# CITY OF ALBUQUERQUE

January 22, 2026

**RE: 8004 Fuji Ct NW**  
**Grading and Drainage Plan**  
**Engineer's Stamp Date: 8/18/25**  
**Hydrology File: E10D088**  
**Case # HYDR-2025-00003**

Based upon the information provided in your submittal 1/9/2025, the Grading and Drainage Plan **is not approved** for Grading Permit and Building Permit. The following comments need to be addressed for approval of the above referenced project.

ENGINEER'S SEAL	LOT 13 BLK 13 U 5 VC 8004 FUJI CT. NW GRADING AND DRAINAGE PLAN	DRAWN BY DEM
		DATE 10-8-20
1/23/26		SHEET # C1
DAVID SOULE P.E. #14522		JOB #

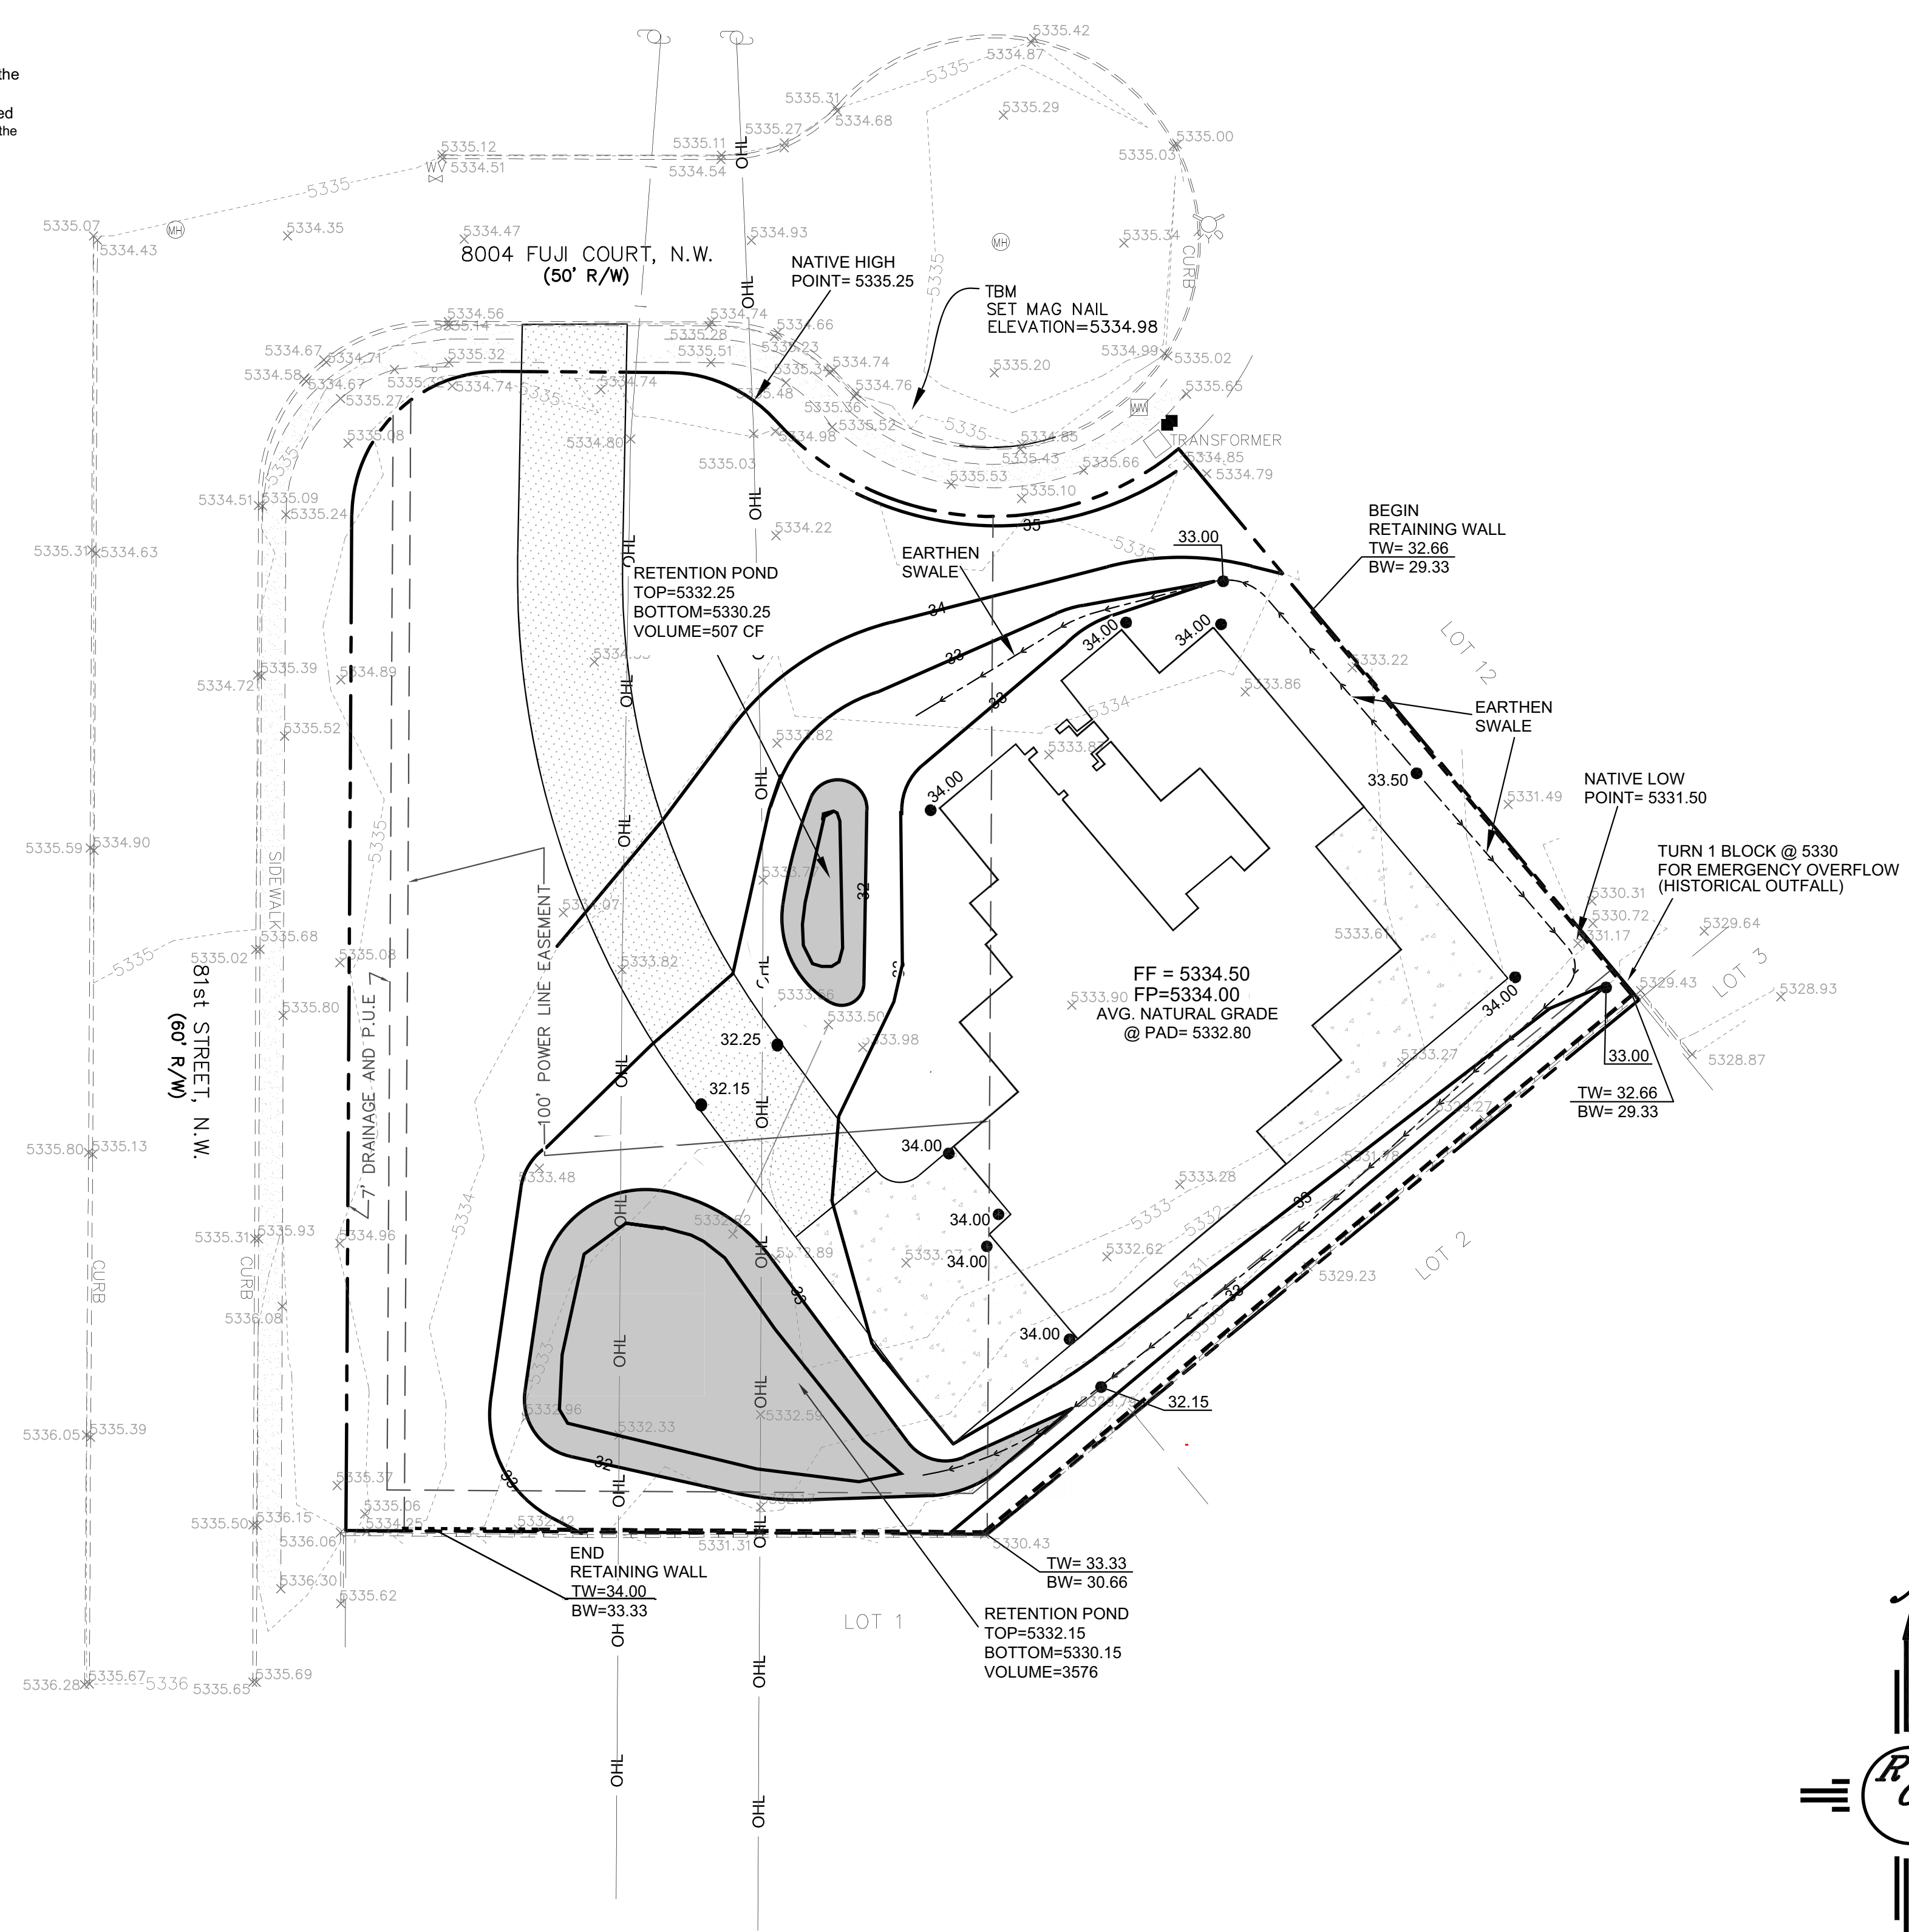
1. Typo for finished pad (FP) elevation – currently says FF. Please update.

2. Please update the narrative to reflect SAD 227 instead of 228. Additionally, ponds are required and shown onsite in the plans.

3. Please provide the FIRM Map floodplain note with effective date.

- Please extend retaining wall on the northeast side of the property to the 5334' contour line per our conversation earlier today.

- Per section 14-5-2-12(B)(2) of the Flood Hazard and Control Ordinances: *Construction, grading or paving on any lot within the jurisdiction of the city shall not increase the damage potential to upstream, downstream, or adjacent properties or public facilities. Damages shall be defined as those caused by flooding from the 100-year design storm and all smaller storms and from erosion and sedimentation resulting from the 10-year design storm and all smaller storms.* Is there an existing cross lot drainage easement? If not, you cannot drain onto the neighboring property without a clear agreement.
